**RFI #: 160**  
**Date:** 6/21/2012  
**Job:** EB-02 Keller Springs Lofts  
**Phone:** 877-777-5115

**Subject:** Wood Posts on B2 Part 4 Unit

**RFI #: 95**  
**Date:** 3/27/2012  
**Job:** EB-02 Keller Springs Lofts  
**Phone:** 877-777-5115

**Subject:** Wood Post Detail

**S3.01**

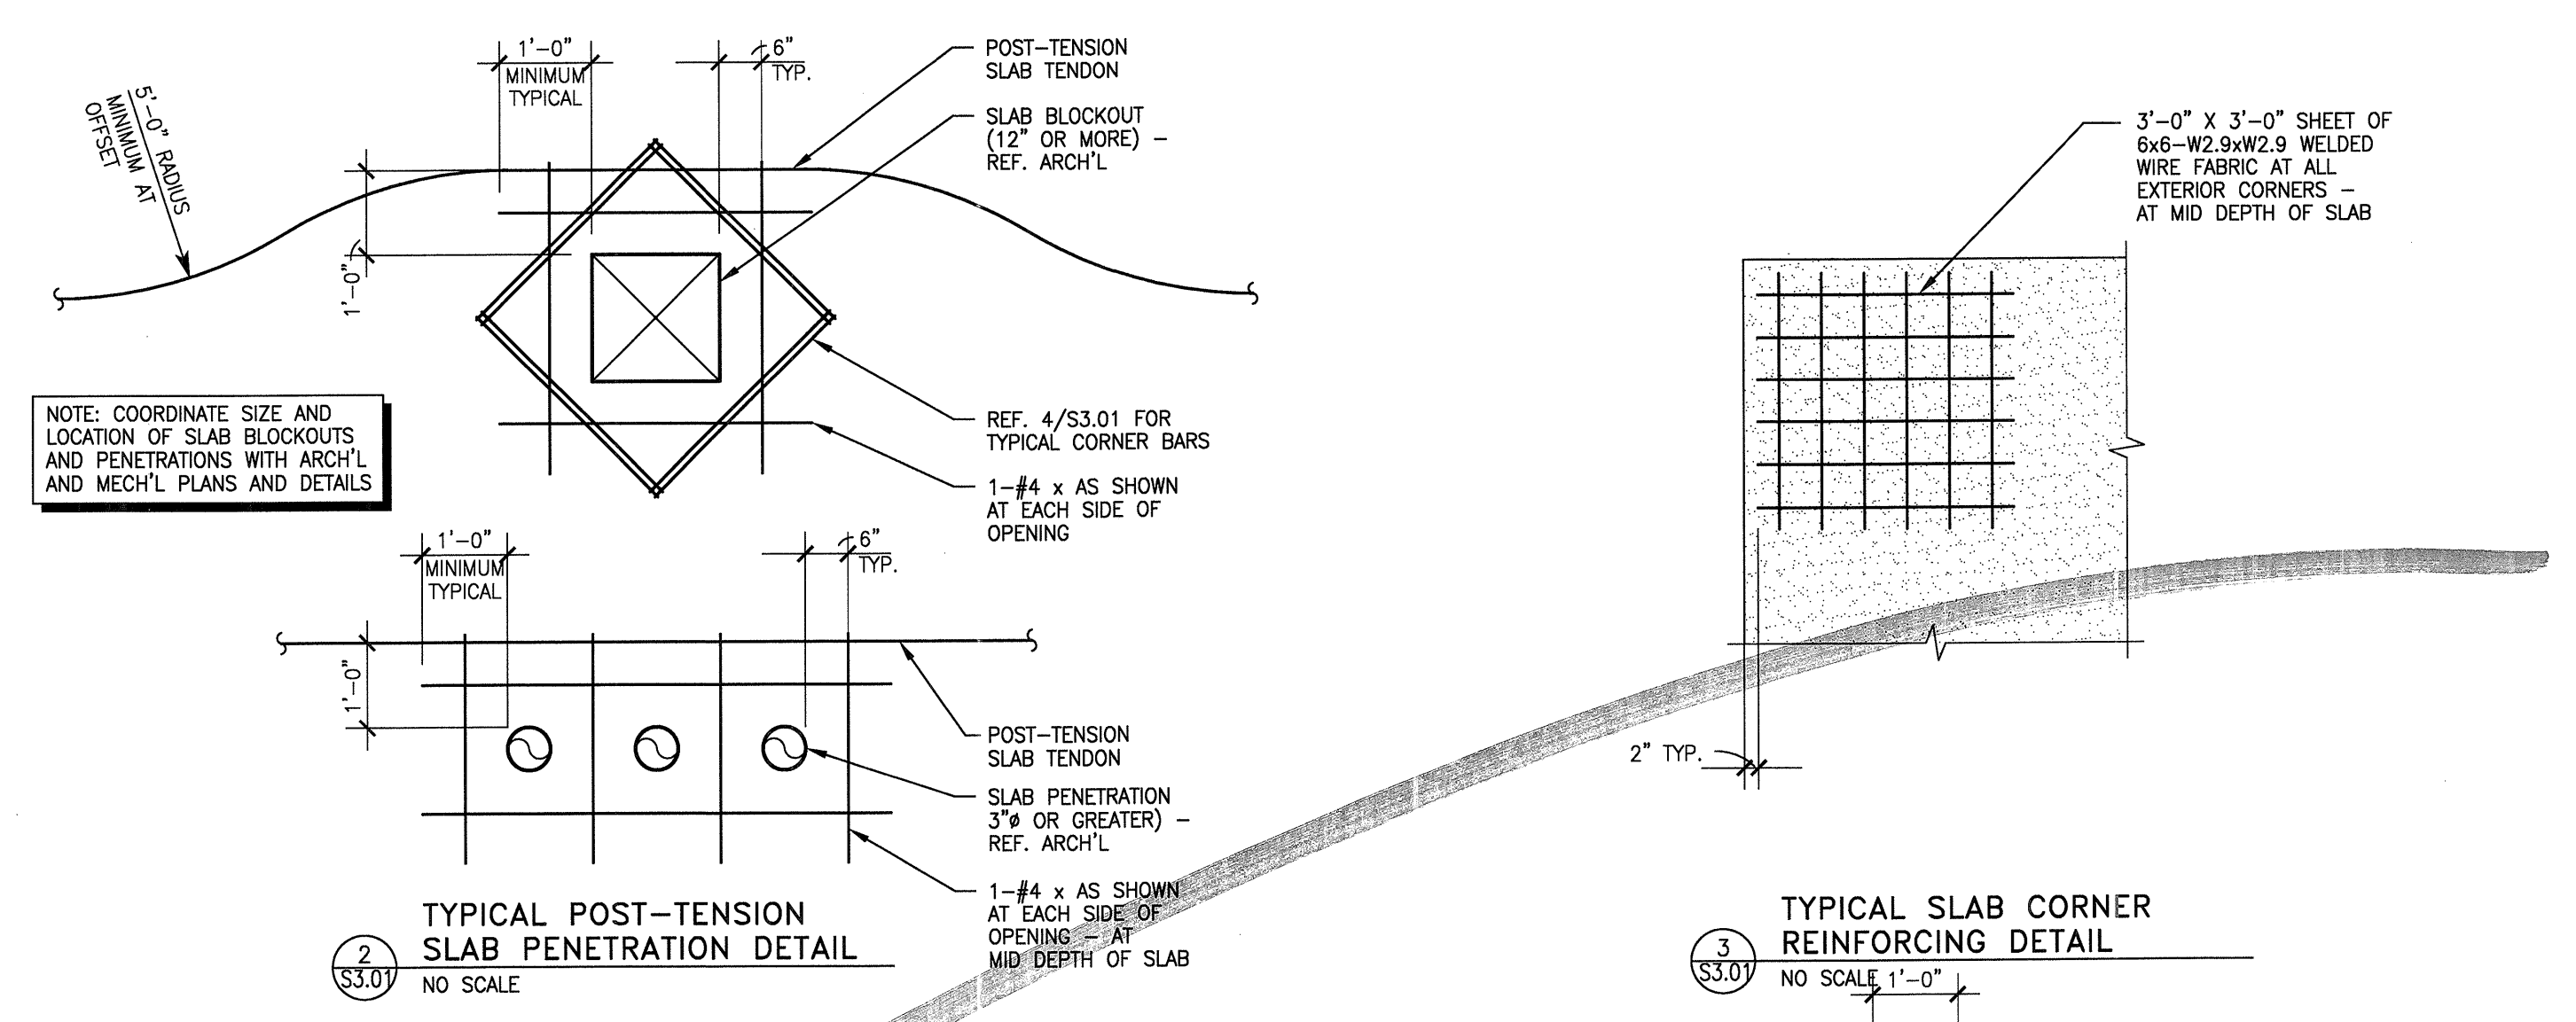
**Request:** Structural plans call for these posts to be 6" wood. Architectural calls for these to be 8". With the height of these columns (11 - 13 plus feet), should they be steel? Also, how do the structural beams attach to the columns, whether wood or steel?

Per BGO, use 8x8 posts.  
Fasten beams with Simpson CCQ Post Cap and to foundation with Simpson ABU Post Base.
